**OXFORDSHIRE COUNTY COUNCIL’S RESPONSE TO CONSULTATION  
ON THE FOLLOWING DEVELOPMENT PROPOSAL**

**Application no:** 22/01611/OUT

**Proposal:** Outline planning application for up to 118 no dwellings (all matters reserved except for access) with vehicular access from Oxford Road

**Location:** Stratfield Farm 374 Oxford Road Kidlington OX5 1DL

Footway Connection – Croxford Gardens
MAC drawing no. 122-TA06

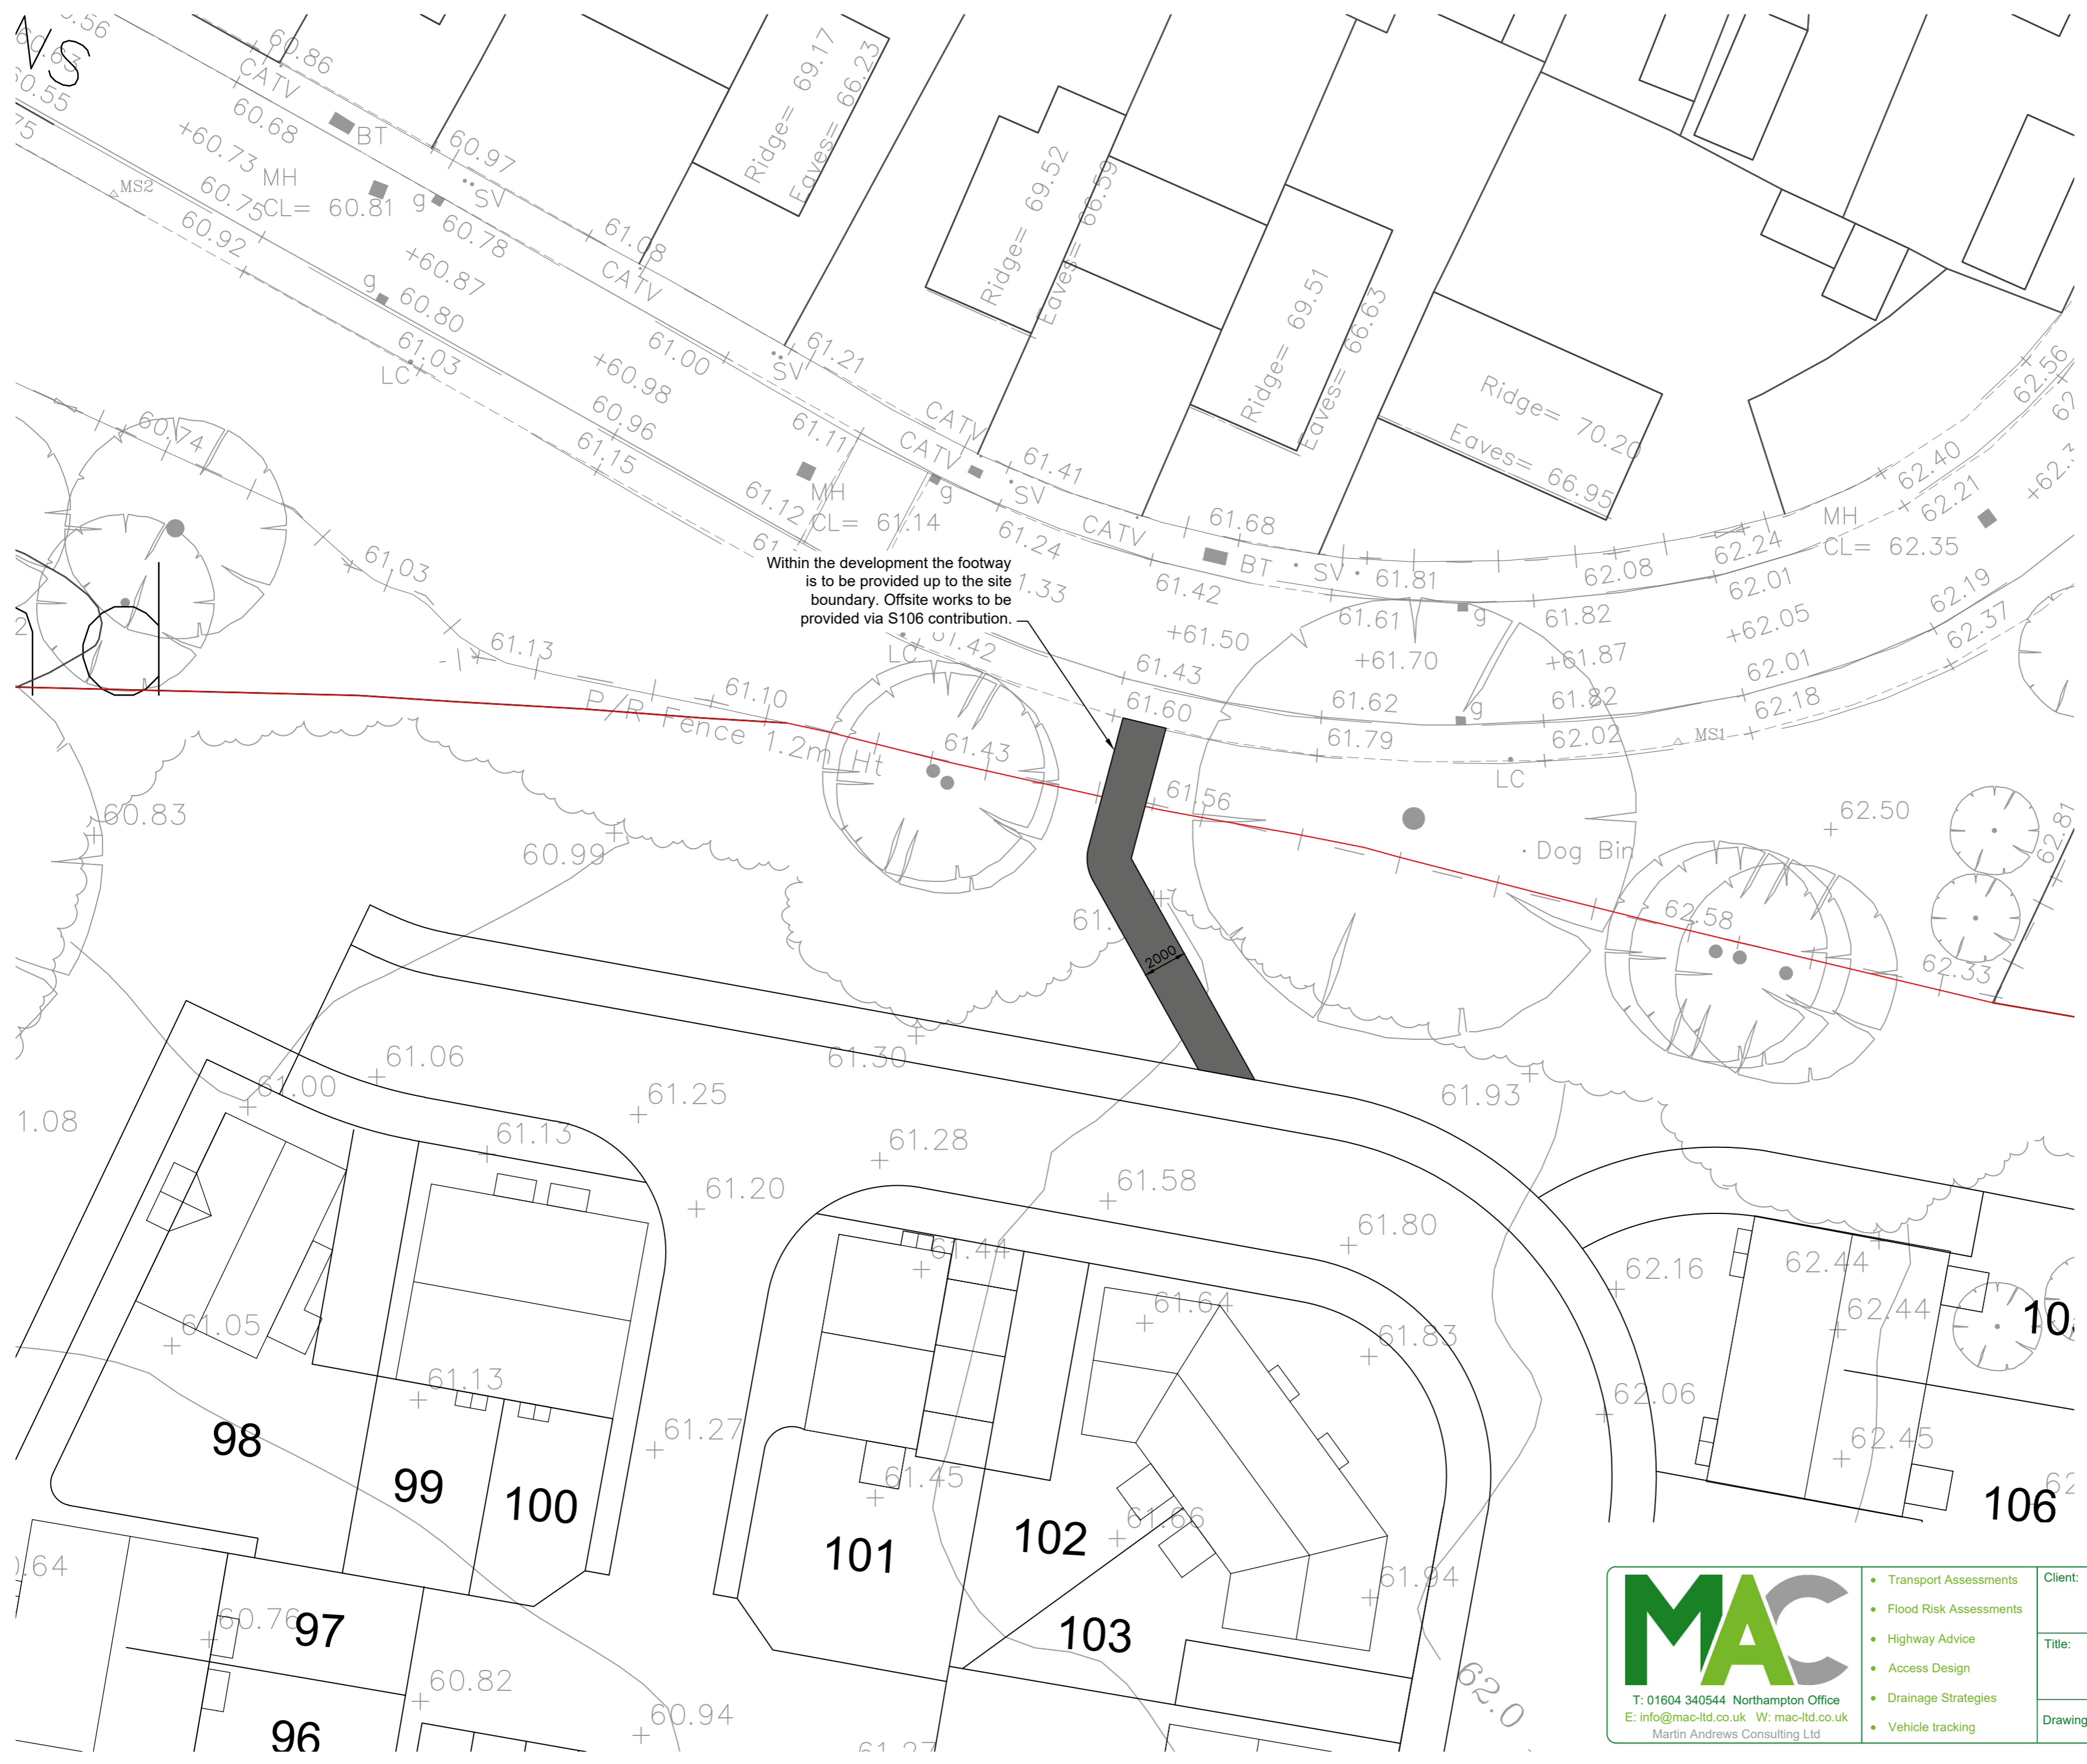
- Again, the pedestrian link onto Croxford Gardens to the north of the site needs to be established at the outset. Provision of an internal walking facility right up to the site boundary as Para 3.3 alludes is incoherent, incomplete and fails its purpose. Provision of a pedestrian access onto Croxford Gardens to make the development permeable as established in the Development Brief. **Objection in Principle**
